Item No. **Report of the Head of Development Management and Building Control**

Address: 79 BRIDGWATER ROAD RUISLIP

Development: Conversion of garage to habitable use, erection of a double storey rear/side extension including the insertion of a new side facing window and erection of an outbuilding to rear garden. Conversion of the existing two storey dwelling into 2no. self-contained flats, with associated front and rear landscaping, bin store and cycle store.

LBH Ref Nos: **2708/APP/2024/16**

9 Proposed Ground Floor Plan
SCALE: 1:100

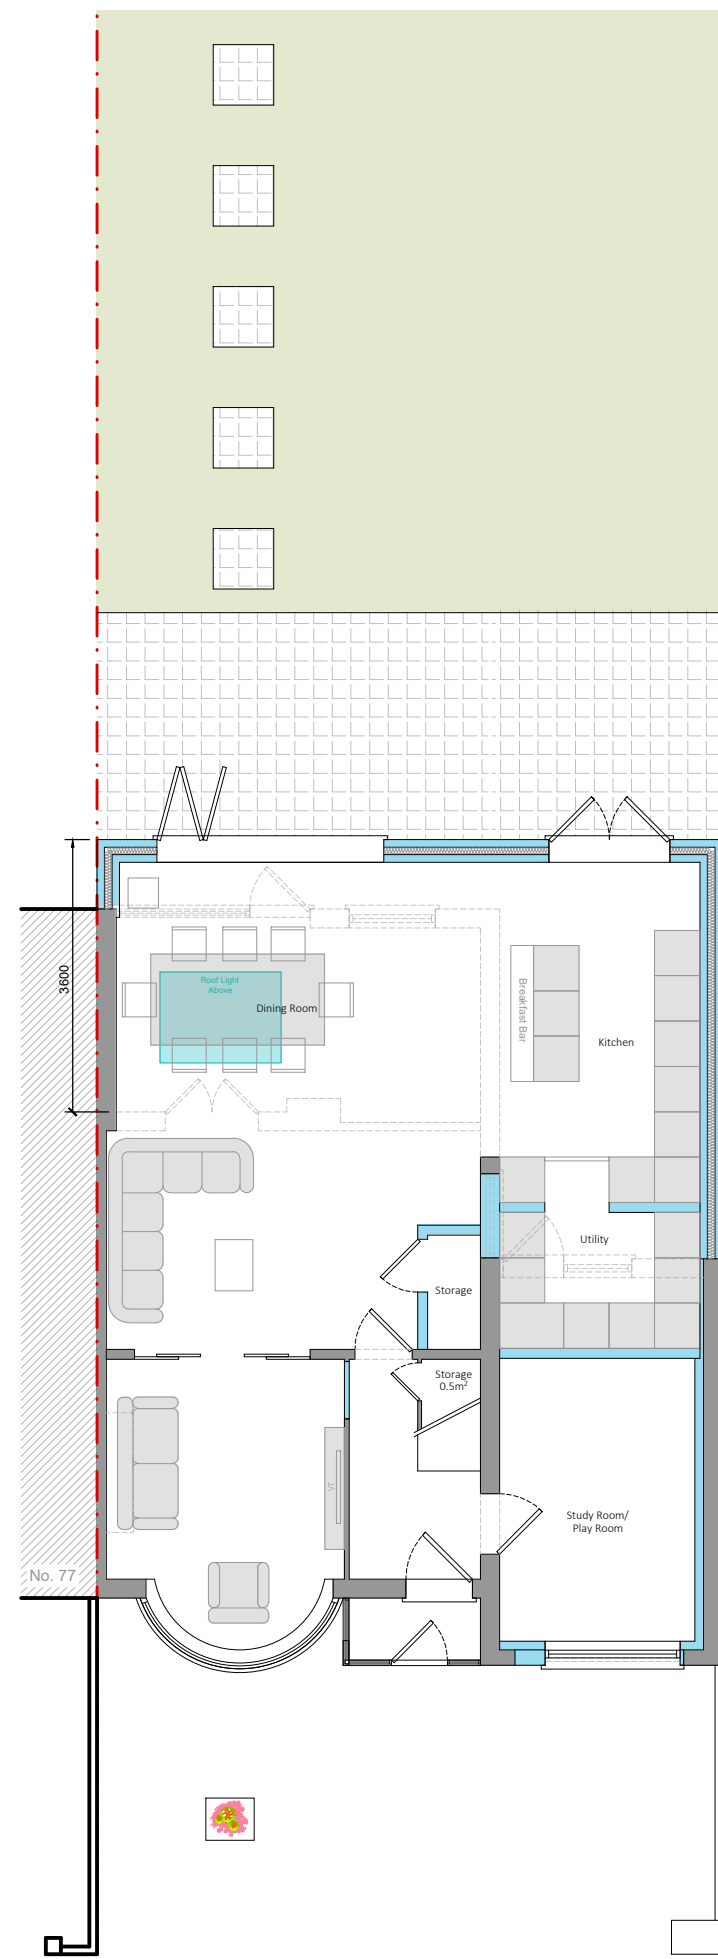
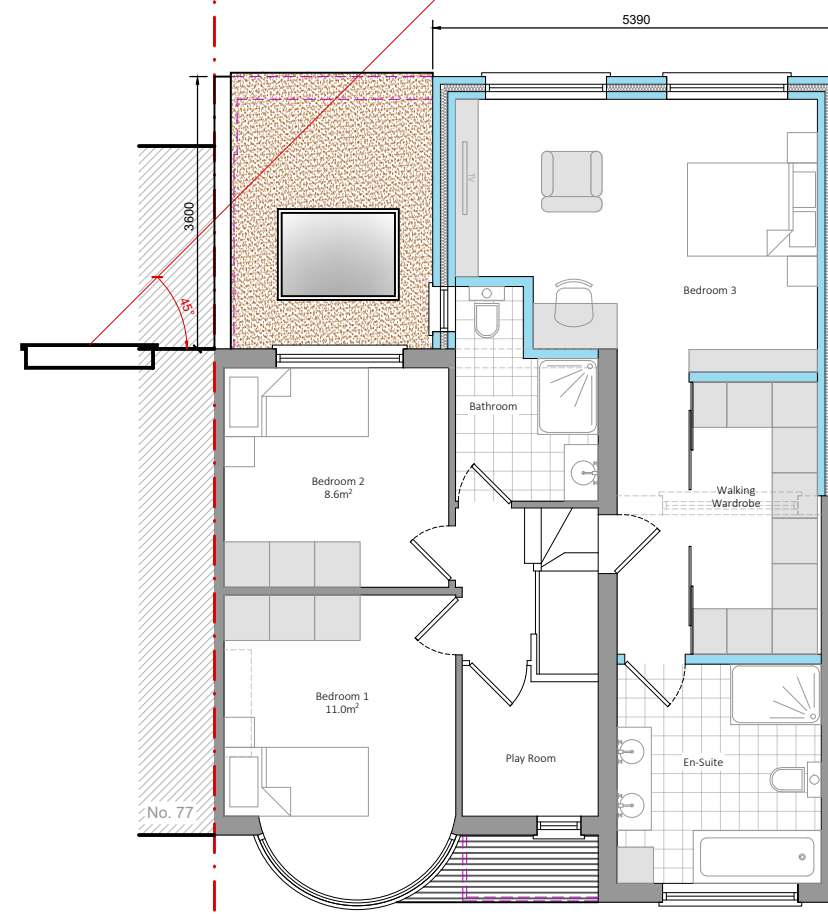
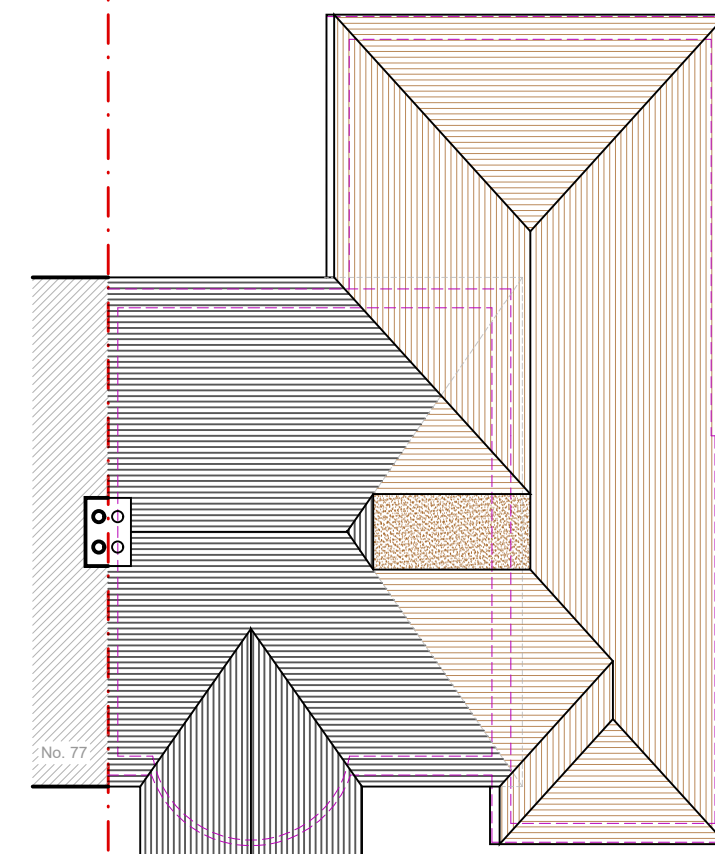
The proposed outbuilding is located along the rear southern boundary of the application. Whilst floor plans have been provided, there are no elevation plans for the outbuilding. The proposed outbuilding will measure a depth of 3.8m and a width of 8m, covering approximately 30 sqm. It is acknowledged that the property benefits from a Certificate of Proposed Use for an outbuilding covering a similar footprint, approved under planning application ref: 2708/APP/2023/1832). However, in the absence of Proposed Elevations for the outbuilding, it has not been possible to access the design implications. It is noted that the floor plan is accurately in line with the

However, the bedroom windows on the ground floor flat (Flat A) would face onto the parking/access court with little detail of the defensible space to provide a buffer or degree of privacy. As a result, it is likely that future residents of the development and visitors would need to walk directly past the bedroom windows to access the property and vehicles, resulting in a loss of privacy and potential noise disturbance. There is provision for one parking spaces facing Flat 1 Bedroom 1 and given the close proximity from the bedroom window and parking spaces, there is particular concern that the proximity would result in disturbance and loss of privacy.

The application proposes to divide the existing rear garden into separate spaces for each flat. However, there is ambiguity regarding the allocation of gardens to each unit. According to the Proposed Plan & Details Plan, Flat A would have 100m² of private amenity space, while Flat B would be provided with 54m². The proposed layout lacks clarity in terms of boundary demarcation or subdivision between the two gardens. Access to the garden for Flat A is facilitated through rear doors on the ground floor. In contrast, occupants of Flat B would need to exit the property via the front elevation door, proceed around the access road, and utilise a gate approximately 25m from the driveway. It's worth noting that there's a security gate on the side access road, requiring occupants of Flat B to open and close it each time they wish to access their rear garden, which is perceived as inconvenient.

Whilst the proposed garden may exceed the minimum of 25 square metres of private amenity space. In qualitative terms there are concerns that the proposed rear garden would fail to be regarded as well located, well designed and useable for the private enjoyment of the occupiers, particularly given its inconvenient access. It is not clear how the gardens would be subdivided in a manner which would ensure privacy for the occupants whilst representing a high-quality scheme and therefore the provision of the private amenity spaces, with its current siting and location, is not considered acceptable.
